**Project ref:** Southampton to London Pipeline  
Project – EN070005

**Date:** 2 April 2020

**Application by Esso Petroleum Company Limited for an Order Granting Development Consent for the Southampton to London Pipeline Project**

### Written Representations on behalf of the Environment Agency

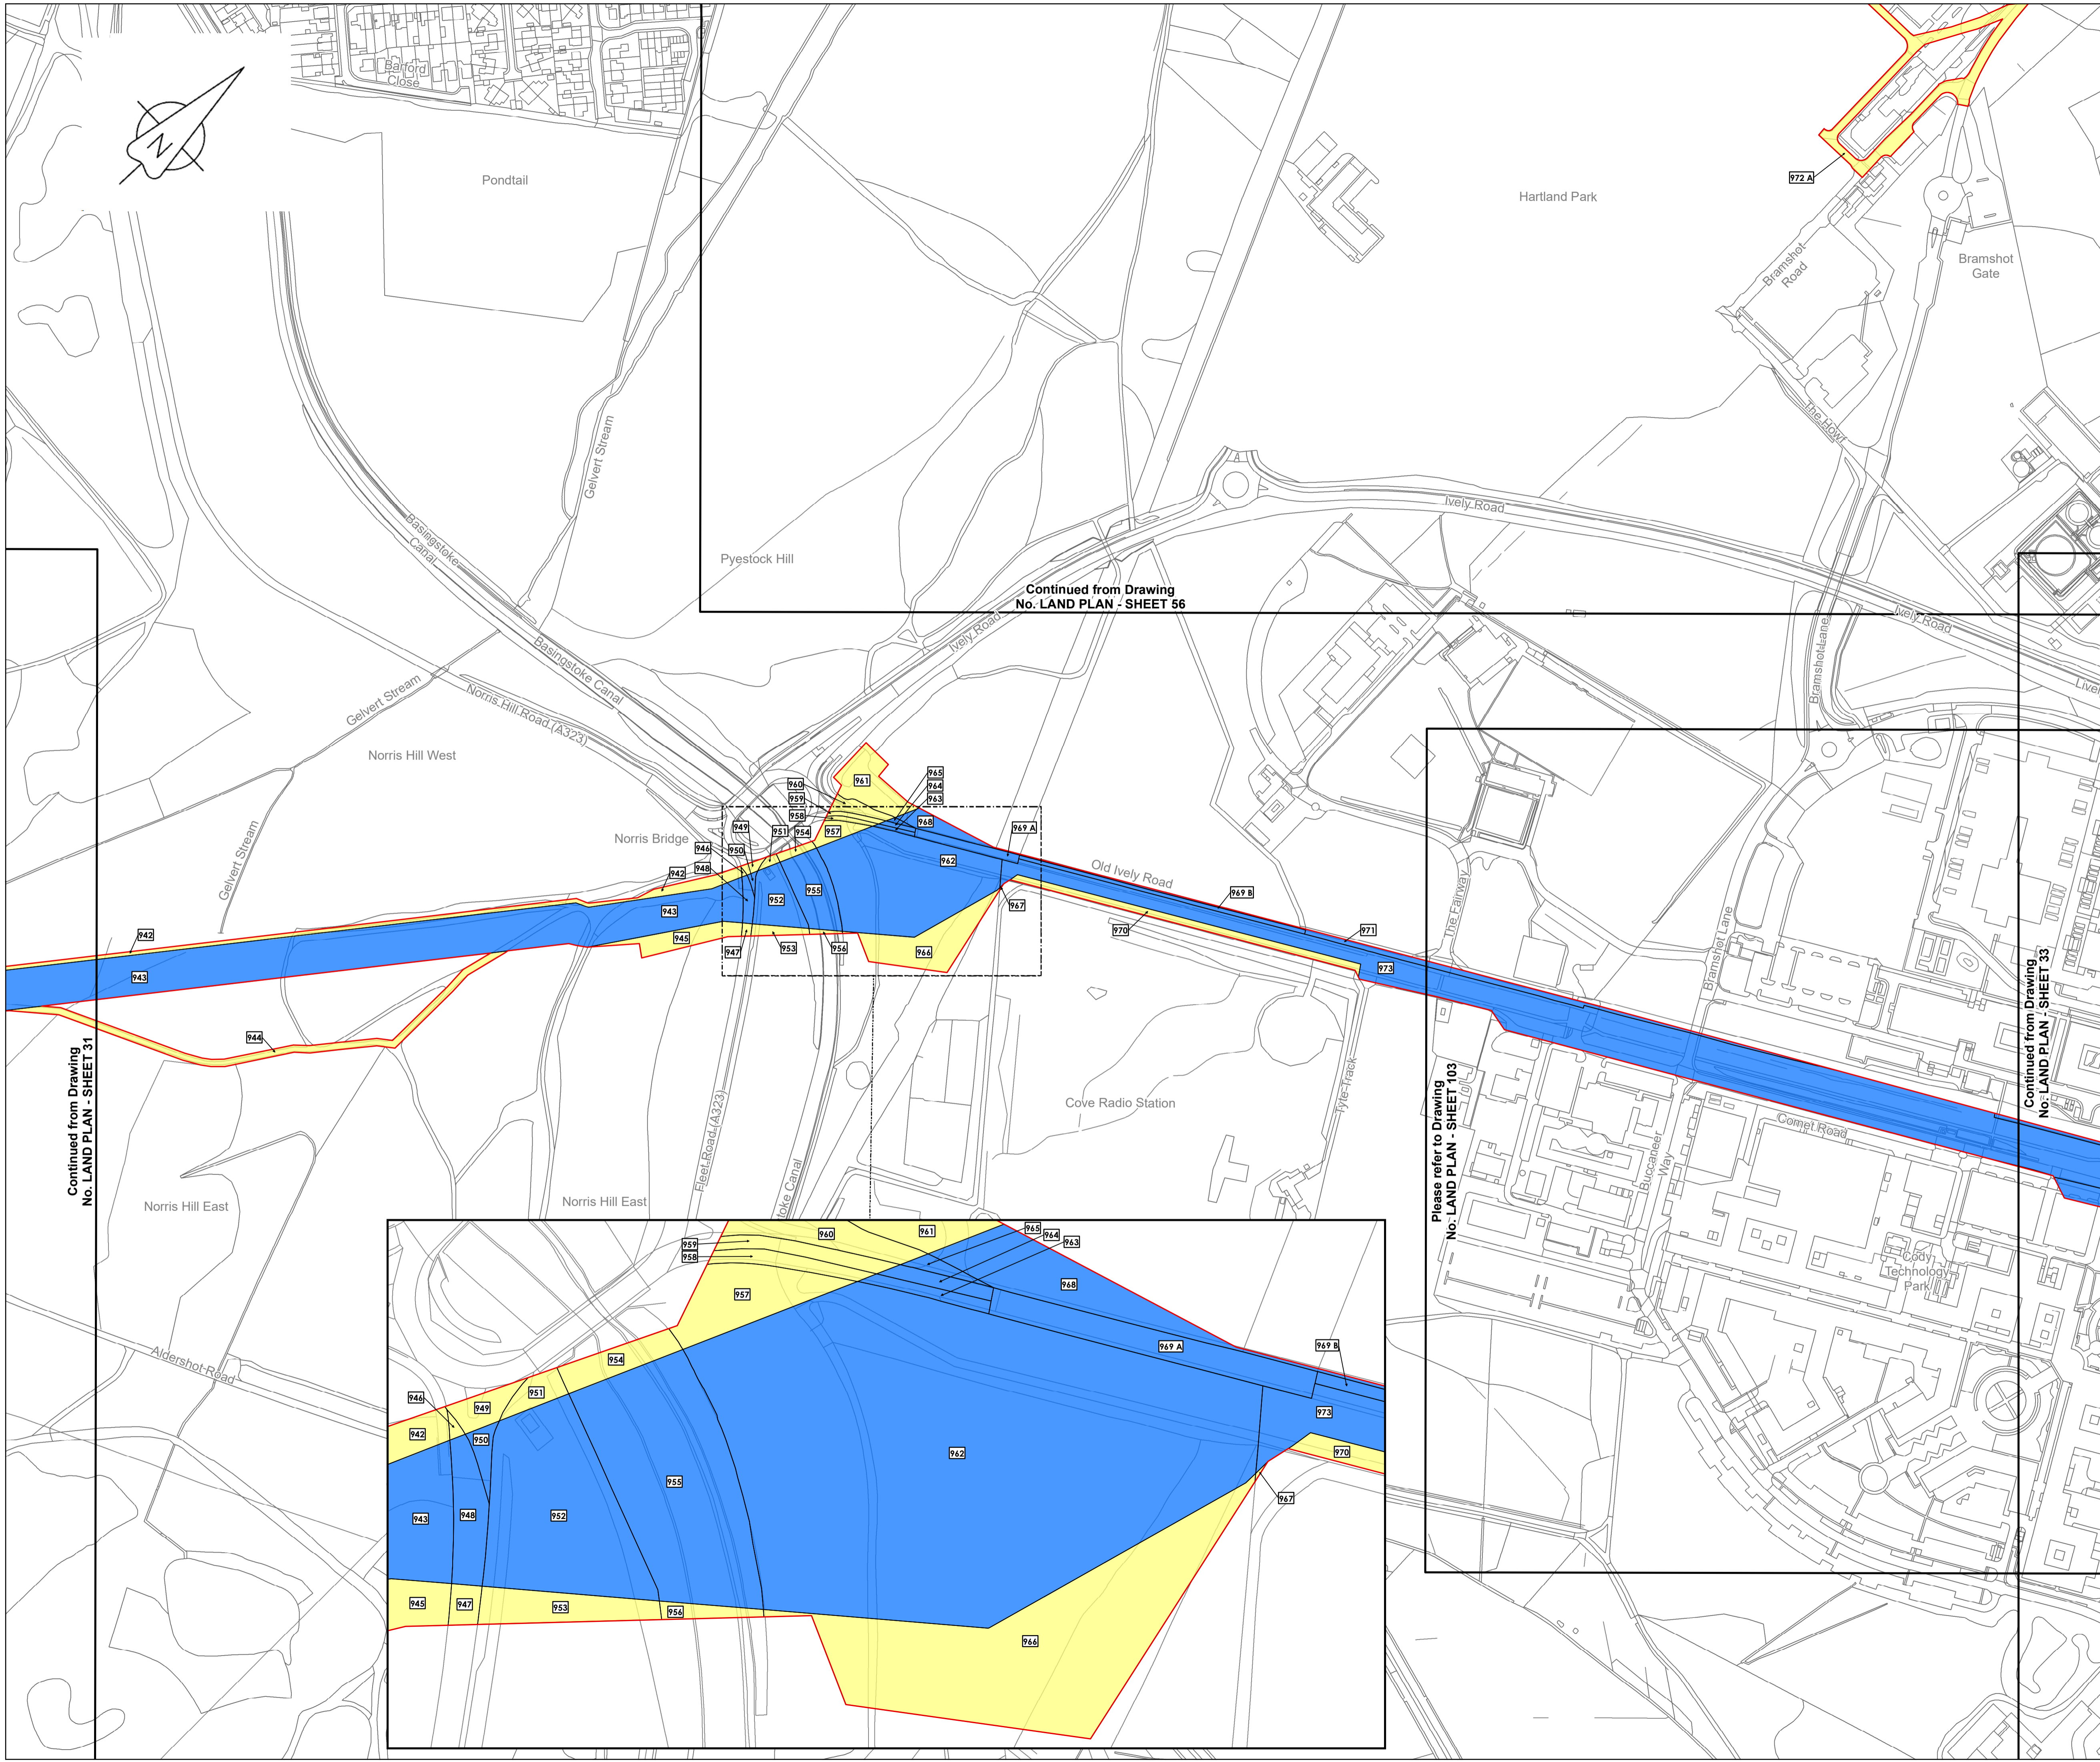
The intake for Channel Section 3 of the River Thames Scheme is connected to the left bank of the River Thames at Thames Side in Chertsey. The Channel is aligned east from the intake through Littleton North lake (a former gravel pit) owned and quarried by Brett Aggregates Limited. The channel then continues through Brett Aggregates Limited land where it is proposed that there will be an intake control structure with associated infrastructure. The channel then crosses Littleton Lane, Shepperton. The area of conflict is within the DCO Plans – Volume 2 Land Plan Sheet 118 (see also Figure 1 below).

To reduce the potential impact on both projects during both construction and future maintenance, our preferred solution is for the pipeline to be routed under the flood channel to the west of the intake structure and associated sheet piling, similar to the proposed crossing of the River Thames a short distance away.

In order for the concerns and issues to be resolved the EA consider that there should be a provision within the Esso SLP DCO to allow further consultation. This consultation between the EA, the applicant and the landowner is required so that agreement can be reached regarding the location, alignment and/or depth of the pipeline to avoid any issues during the construction and future use of the channel.
